Historic England

Our ref: P01398930

1 April 2021

**SOUTH SIDE FORMER SHREDDED WHEAT FACTORY, BROADWATER ROAD,
WELWYN GARDEN CITY, HERTFORDSHIRE
Application No. 6/2021/0671/MAJ**

Figure 5.2: Building Heights within Blocks 9 and 12 (Phase Two)

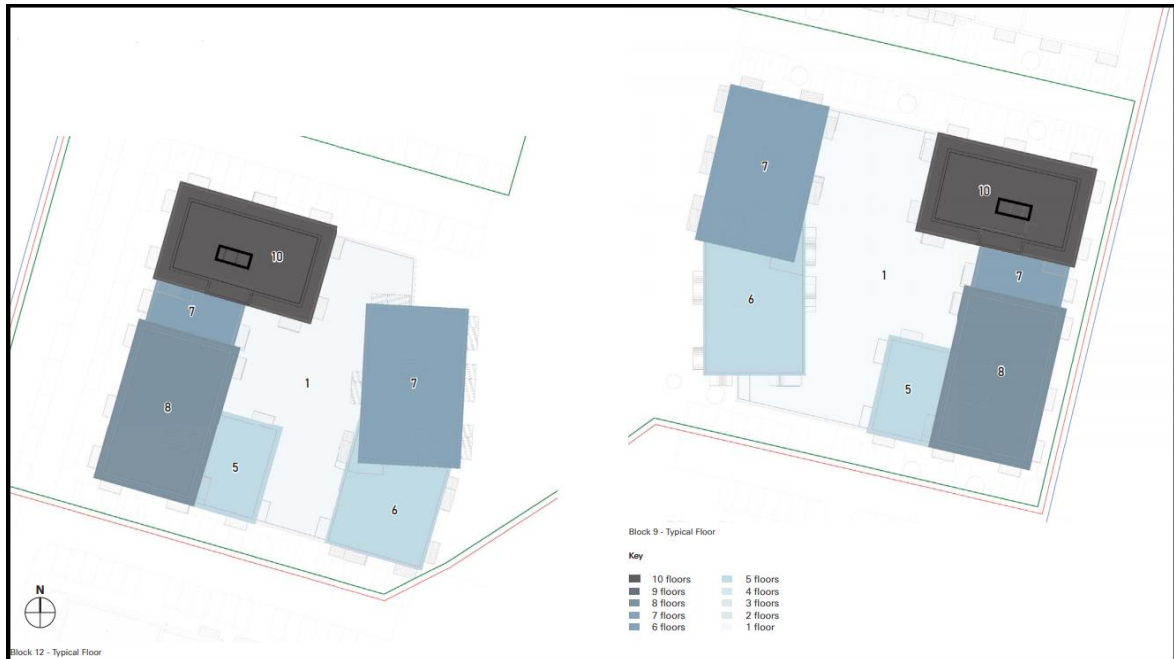
However, we maintain our concerns regarding the overall impact of Phases 2 and 3 of the scheme, which include four blocks at 10 storeys, on the setting of the former factory and on the adjacent conservation area. We consider the impact remains at a moderate level of less than substantial harm.

The proposed revisions to the extant 2019 permission for 643 residential units on the South Side site involve an increase in height of several of the 19 blocks, with the tallest blocks now proposed to be 10 storeys.

At 10 storeys, several of the blocks in Phases 2 and 3 proposals would challenge the dominance of the landmark historic silos of the grade II listed former factory building in views of the skyline, in medium distance views within the conservation area and where the skyline comprises the roofscape of domestic scale buildings.

However, we maintain our concerns in relation to the proposed overall increase in height and scale of the proposals, which would result in a significant escalation of the visual intrusion of the scheme in close proximity to the grade II listed former factory and the wider townscape including the conservation area.

The silos have been a dominant feature on the Welwyn skyline since their construction in 1925 and the proposals in their current form would remove that dominance.

Figure 5.3: Building Heights within Blocks 8 and 13 (Phase Three)

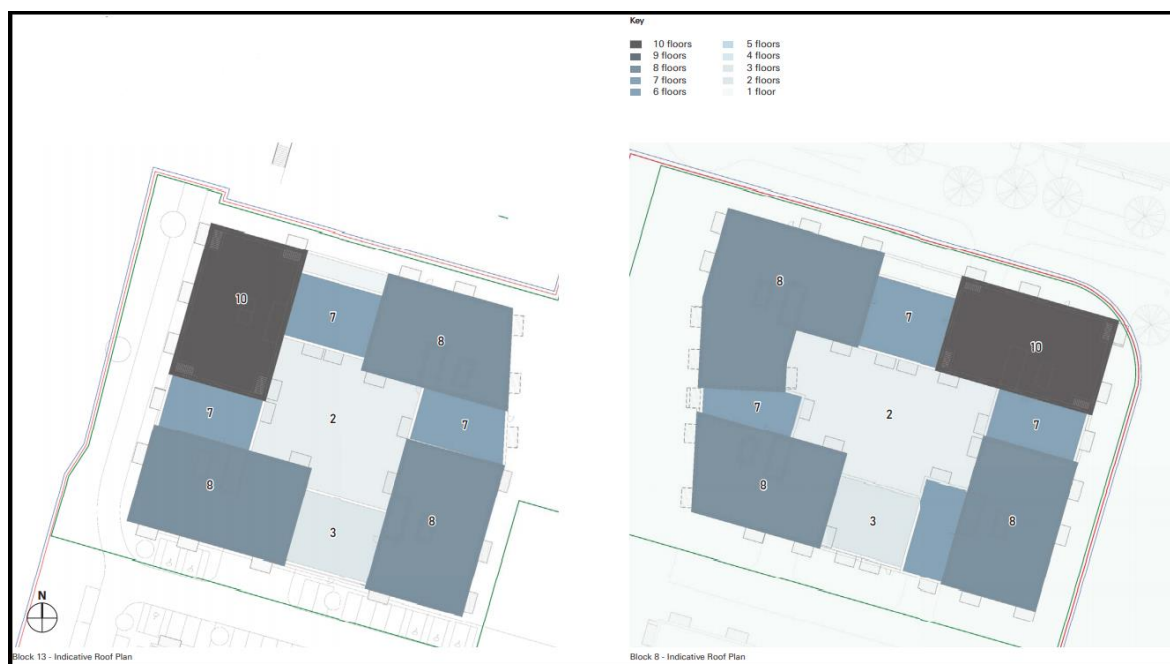
Regarding the current, formally submitted proposals, we welcome the reduction in height of the tallest block in Phase 3 from 13 to 10 storeys, which has resulted in the impact of the development being reduced to a low level of less than substantial harm in views from Hatfield House.

welcome the reduction in height of the tallest block in Phase 3 from 13 storeys to 10 storeys.

The development would now incur a low level of less than substantial harm in views from the wider setting of Hatfield House and Gardens.
